Subject: RE: Planning Consultation on: Y/52/22/DOC

Engineers Comments Regarding Surface Water Drainage

Site Address: Stakers Farm North End Road Yapton BN18 0DU

Description of Works: Approval of details reserved by condition imposed under Y/105/19/PL relating to conditions 3-flint flooring and stall dividers, timber ceiling details, 4-flint flooring details, 5-surface water drainage and 9-electric vehicle charging.

TITLE
Proposed Drainage and Levels Layout plan

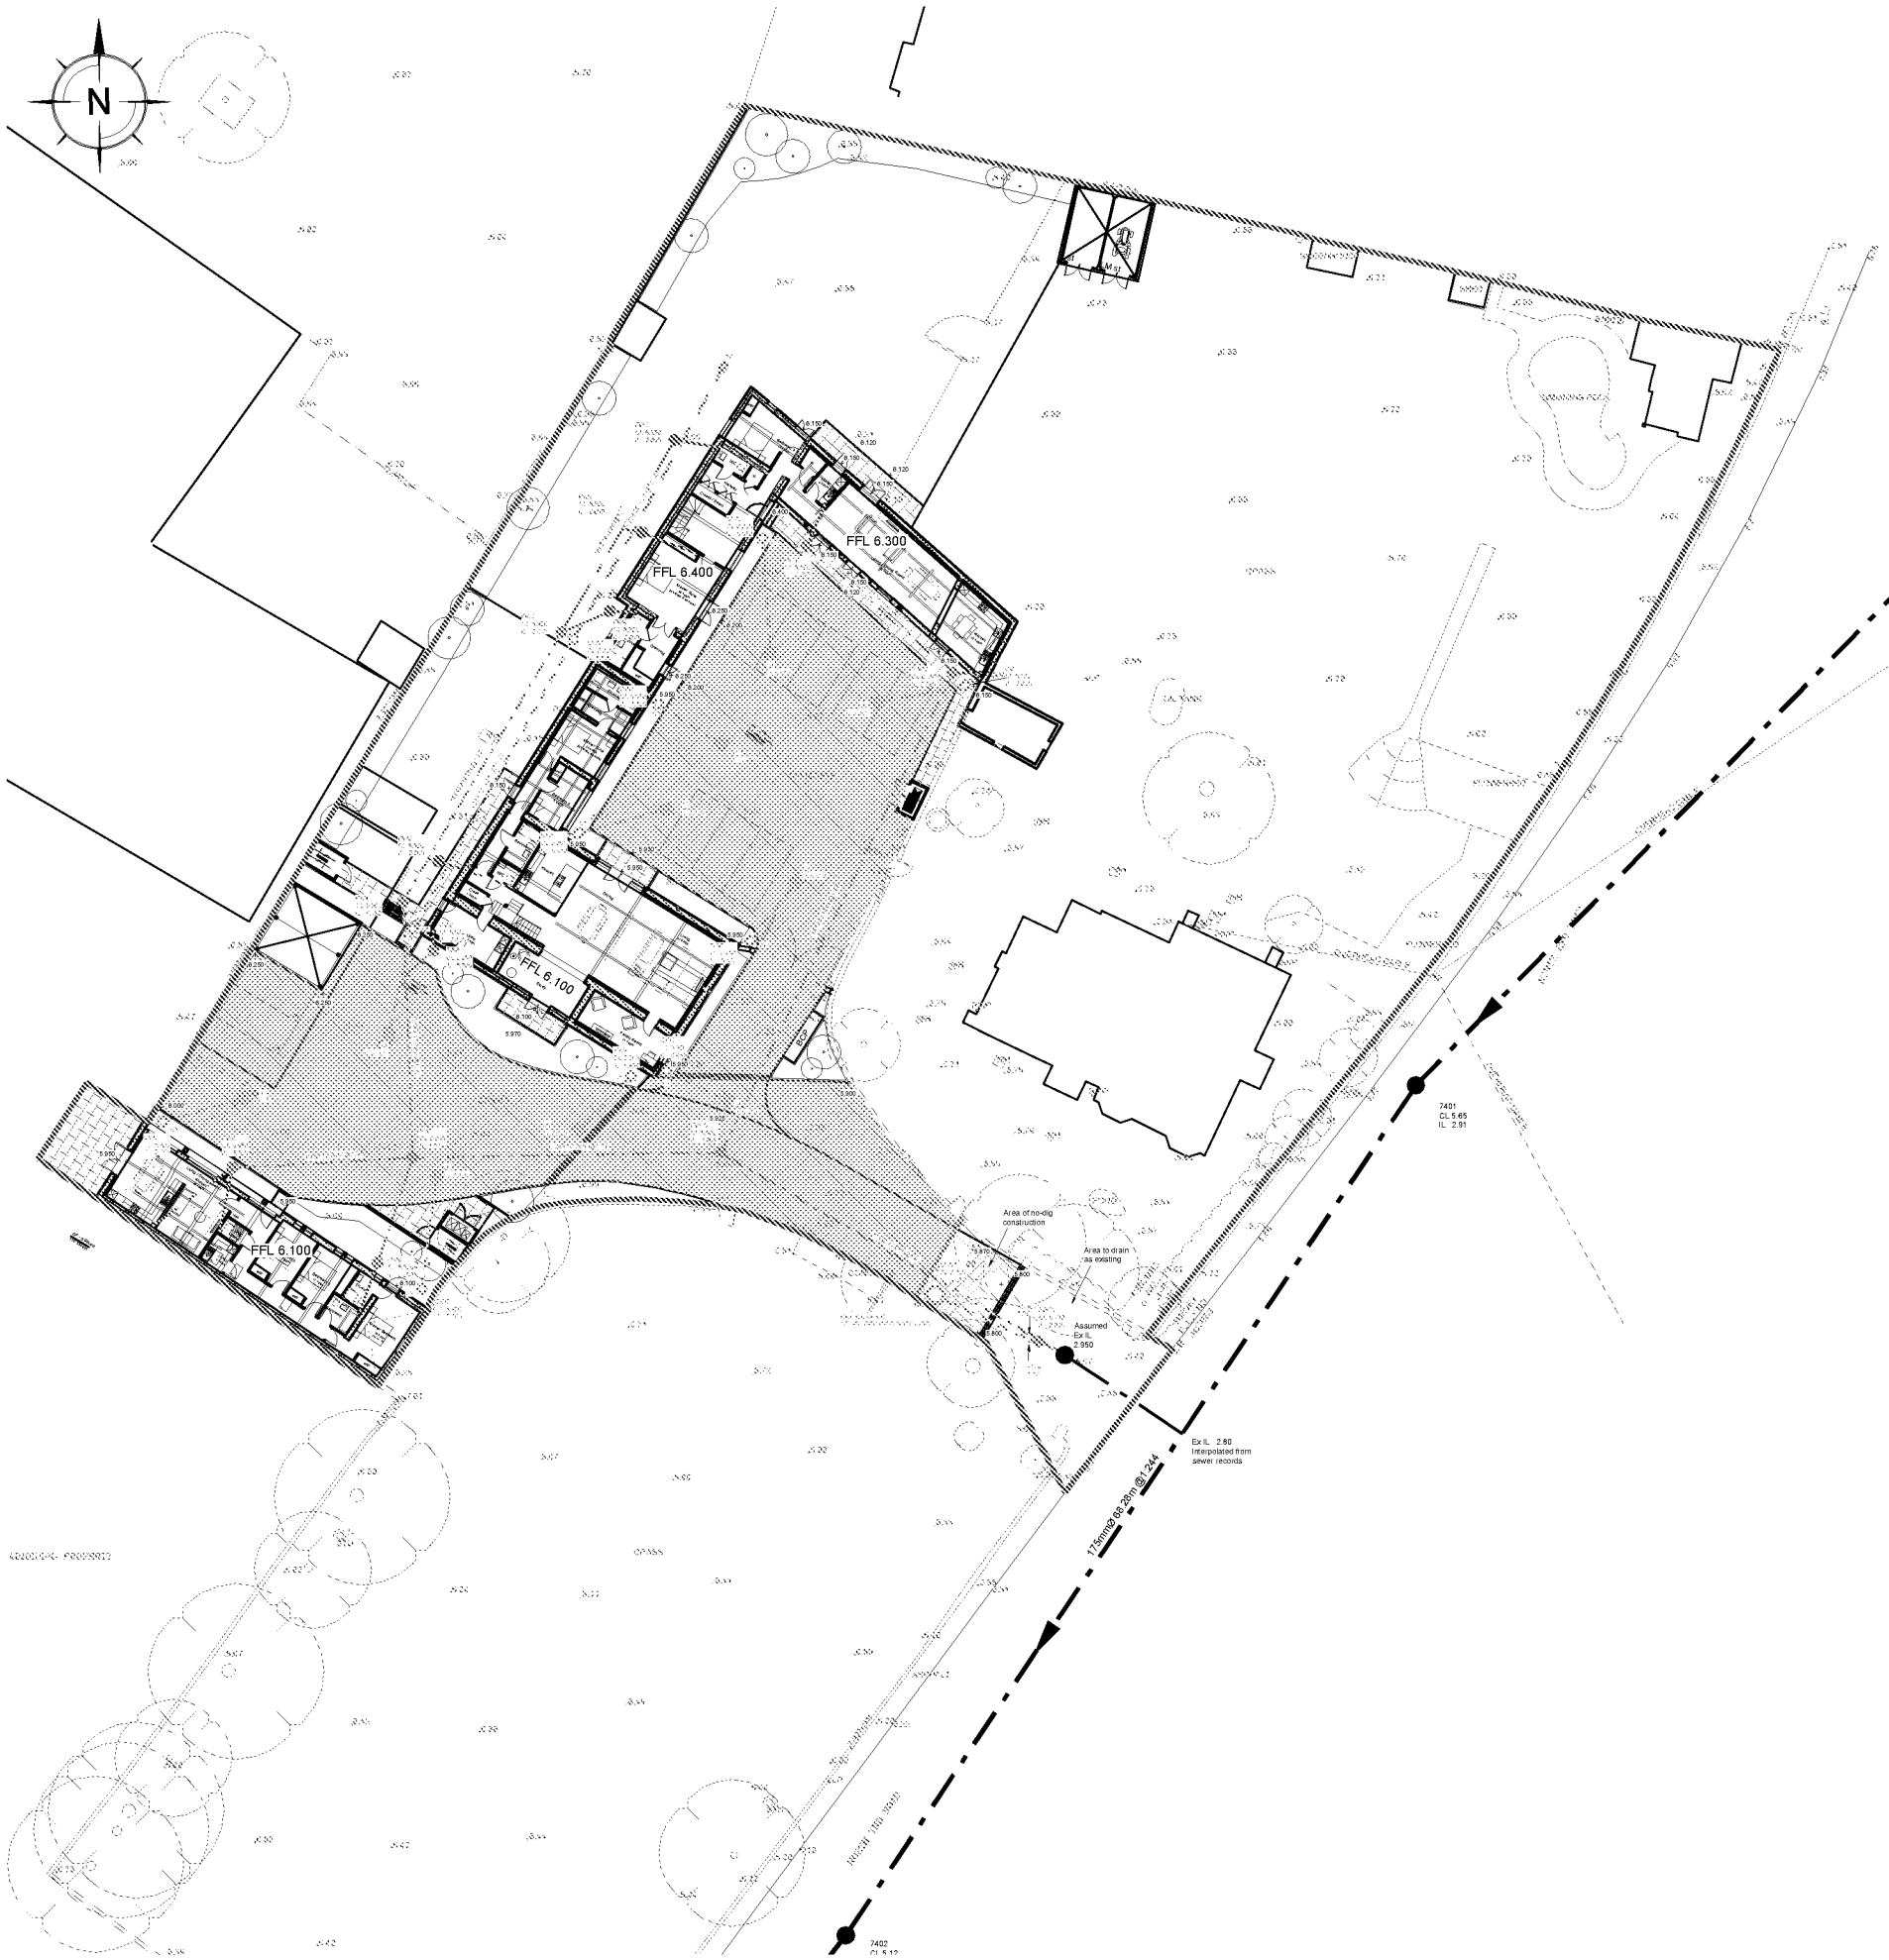
- Service corridors for other services provided to the buildings should be shown, or a statement provided detailing how these will be successfully implemented within the scheme.

- We appreciate a reduction in flows has been achieved, however, we need to see agreement with Southern Water for any connection to the public sewer system. In this case, we also note our mapping shows a surface water highway drain on the opposite side of the road to the proposed development, which would present a preferred point for discharge in our hierarchy of discharge options. We therefore require:

- The design to be amended so that runoff is discharged into the highway drainage network, alongside an agreement with West Sussex Highways for this connection.

MANHOLE WITH HYDROBRAKE
(Scale 1:25)

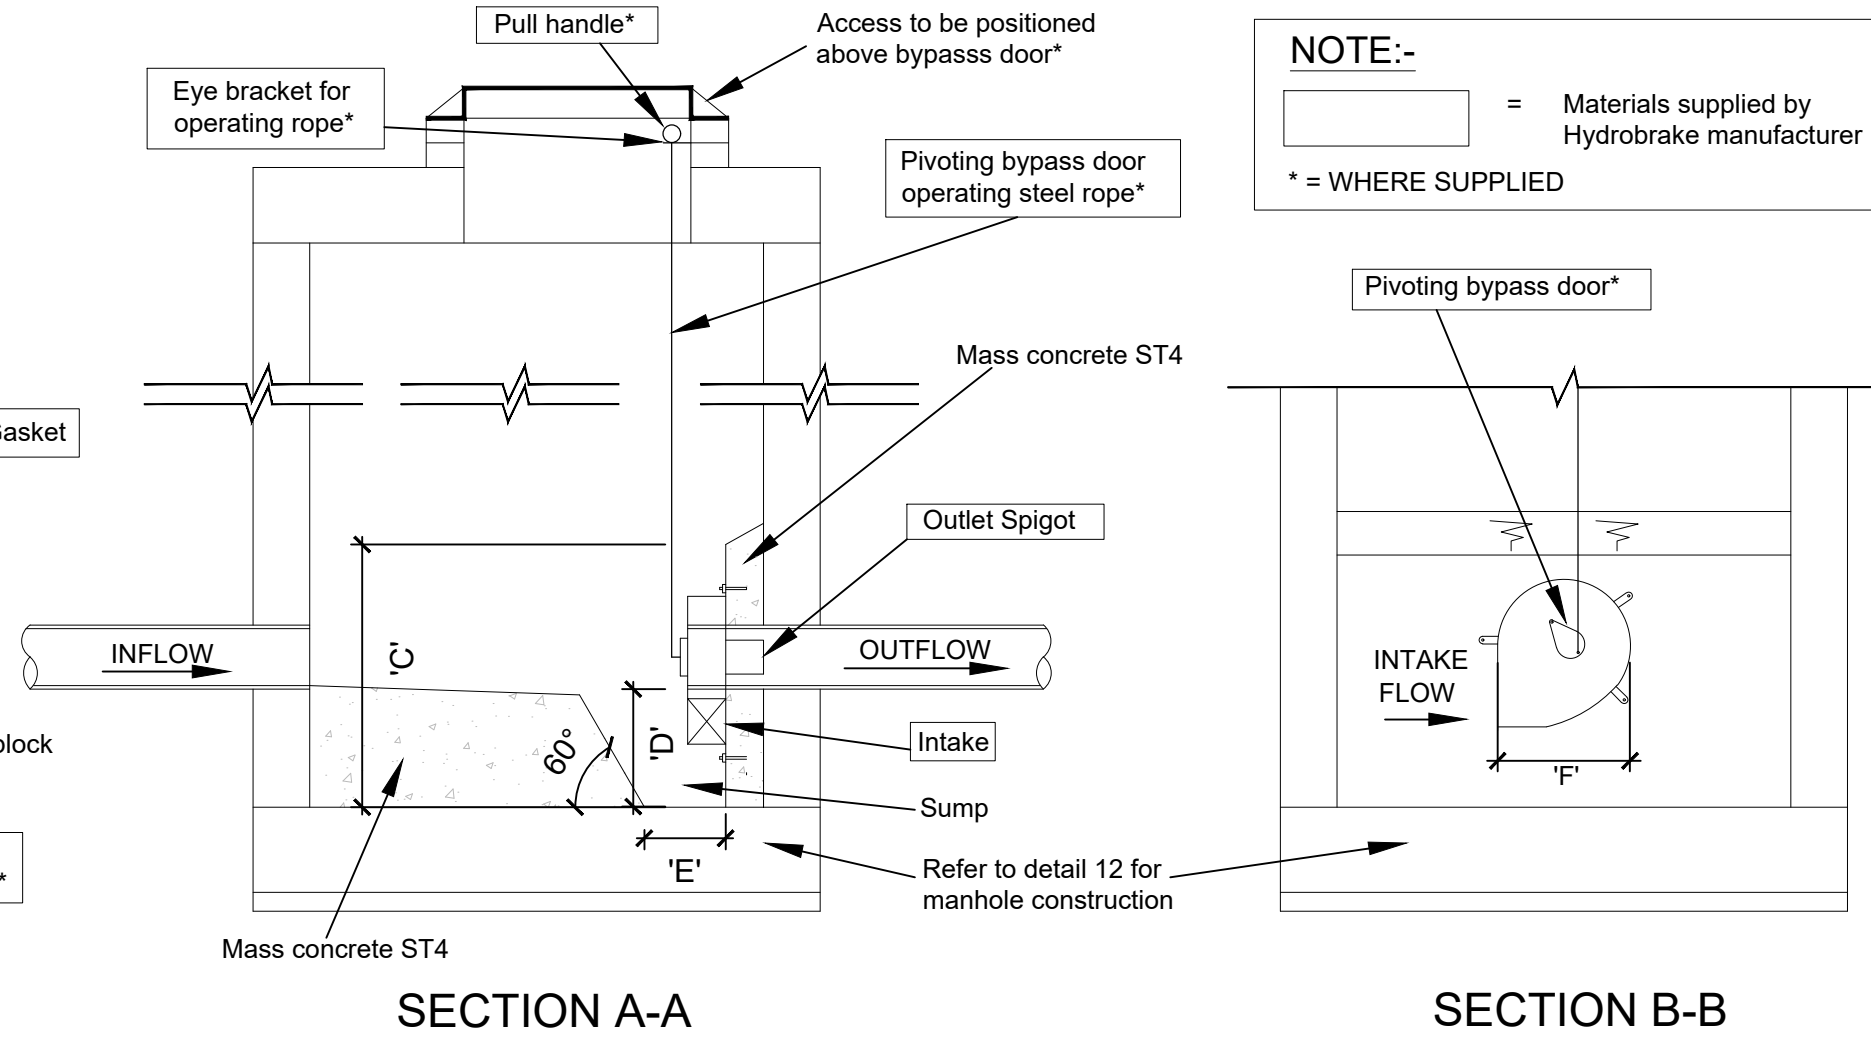
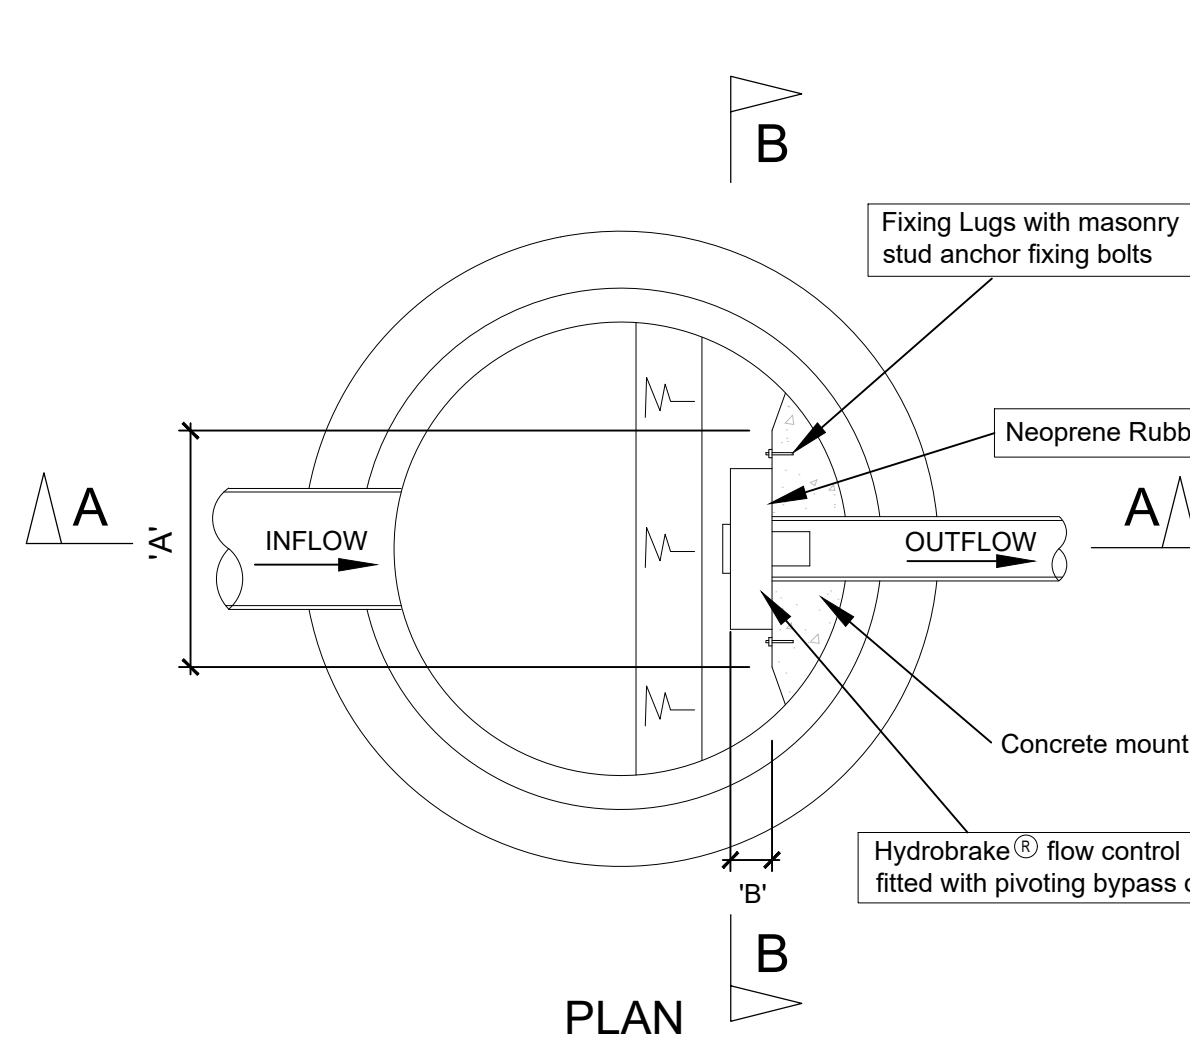
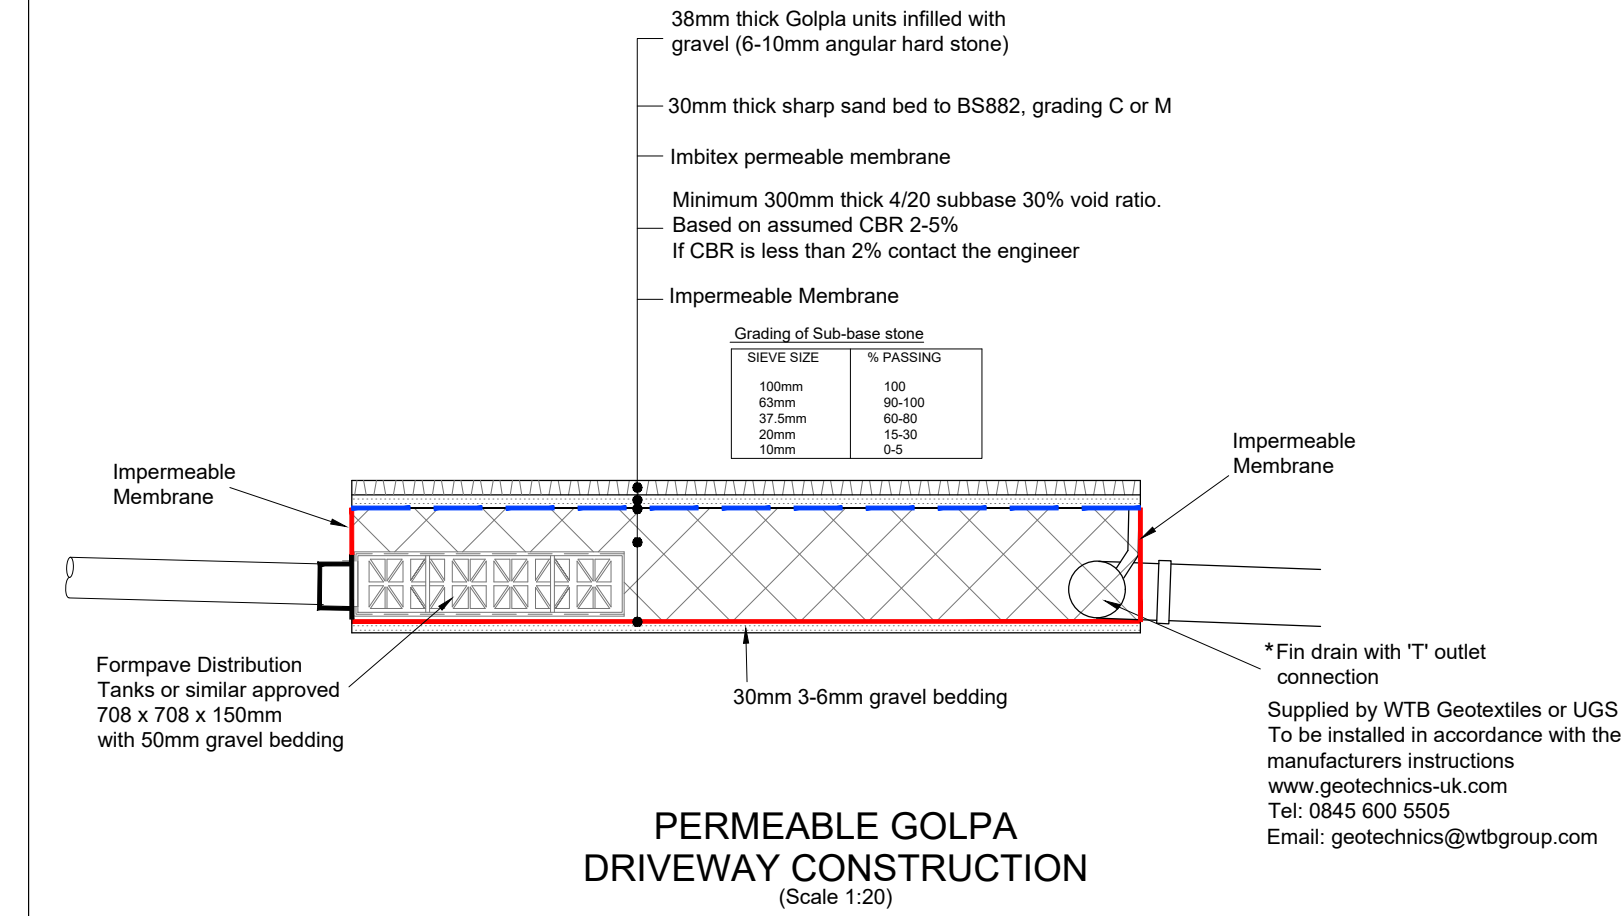
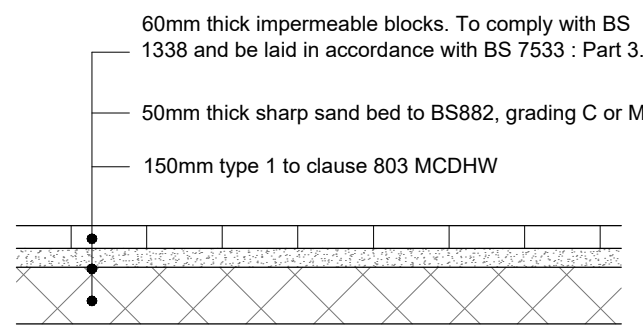
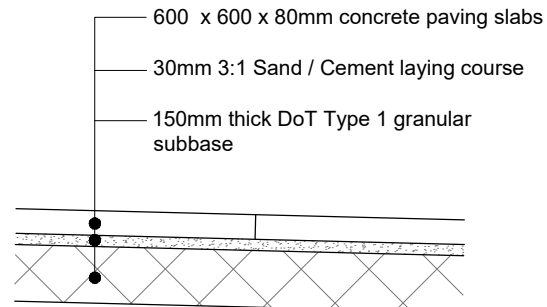
- The invert level for the diffusion boxes has been provided, however, we request that the invert levels of the paving sub-base / bed levels are also provided in these locations, as the section drawing shows these to be different. This is also being requested to enable us to check that the diffusion boxes are located above the critical 1:10 (+40% climate change) water level within the sub-base. Without these values insufficient information is available to confirm that the peak water level within the paving sub-base will be contained within the sub-base.

- The Hydro-Brake manhole is deeper than 1m, building regulations recommends manholes of this depth to have rungs or a ladder, which is not shown on the cross-section drawing. Justification for why this has not been shown should be provided, or the drawings updated accordingly.
